Our Ref: LU/83/17/A

**Town & Country Planning (Control of Advertisement) (England) Regulations 2007 (as amended)
Application for Consent to Display an Advertisement(s)**

Development See Application Form

Location Wickes Building Supplies Broad Piece Littlehampton

Wickes
Broad Piece Wick
Littlehampton
BN17 5RA

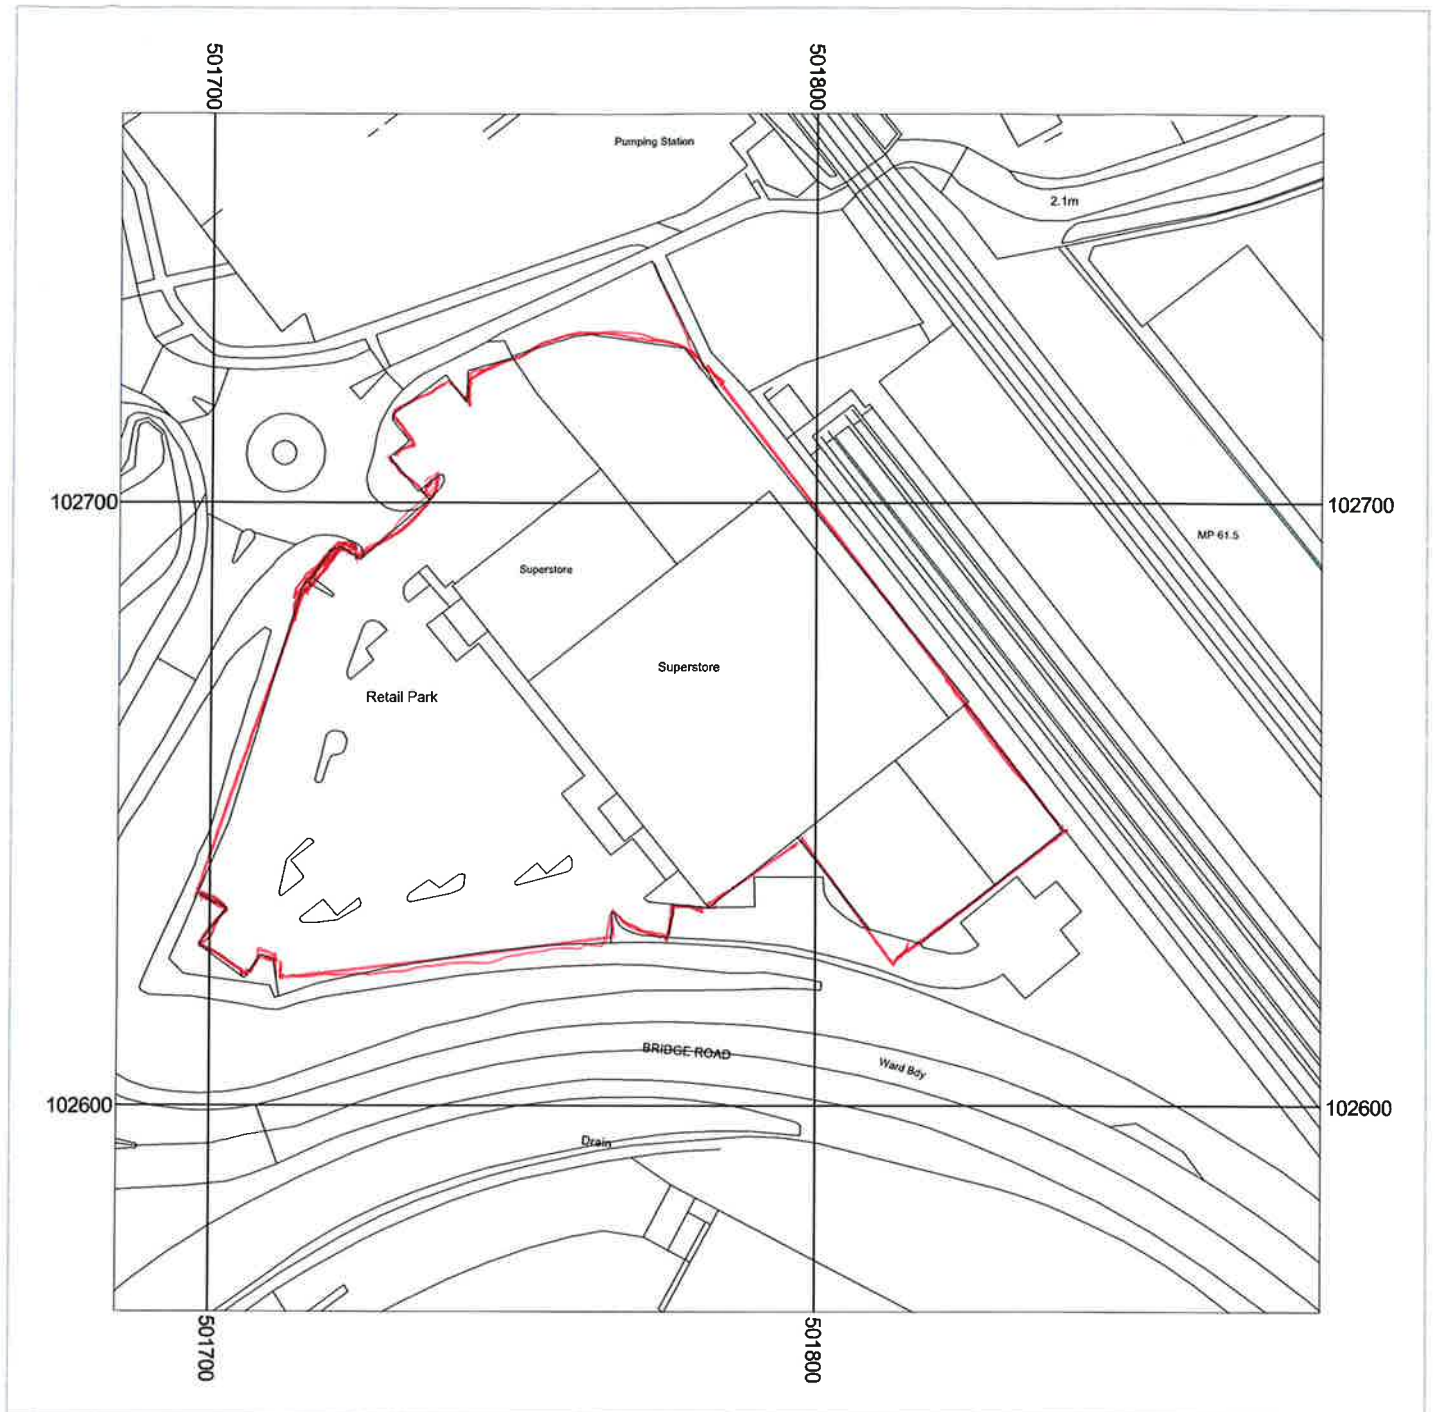
Location Plan

The site does not wholly fit within the location plan. Please submit one at a higher scale.

PROPOSED

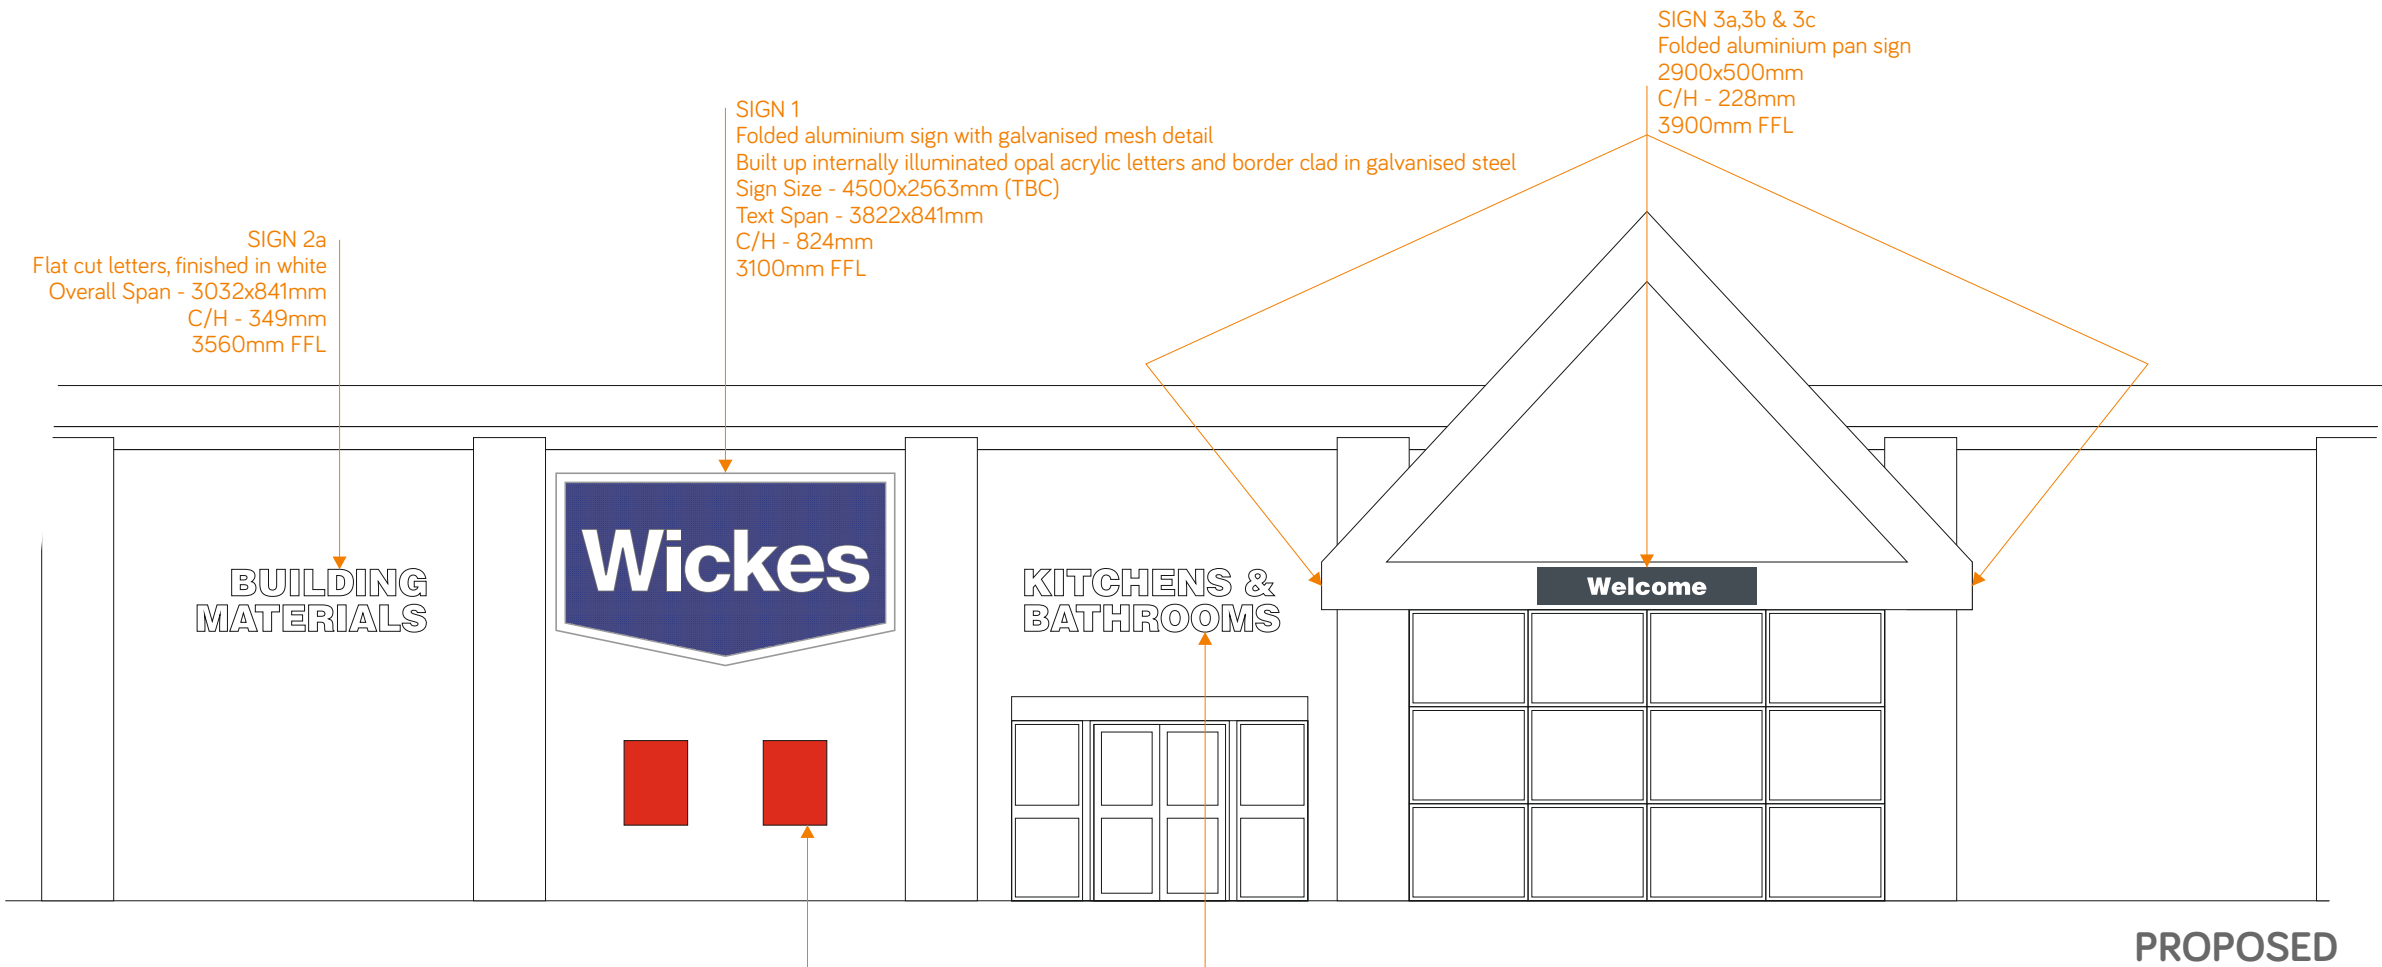
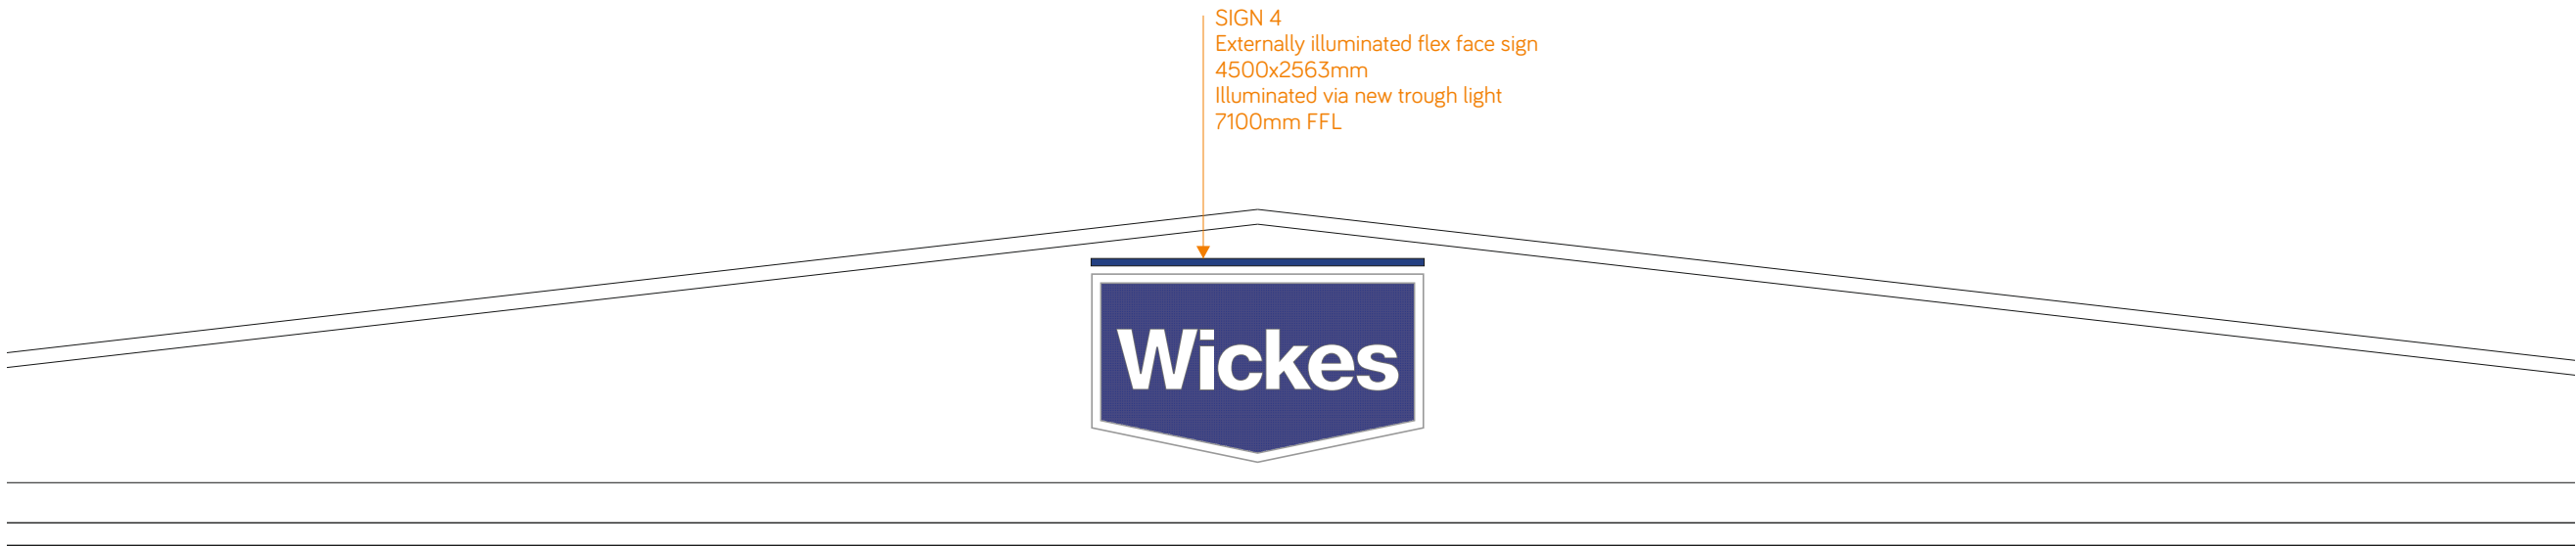
Elevations

Please submit proposed elevations drawn to a stated metric scale such as 1:50 or 1:100. These elevations need to demonstrate all dimensions of the signs including the height from the ground to the base.
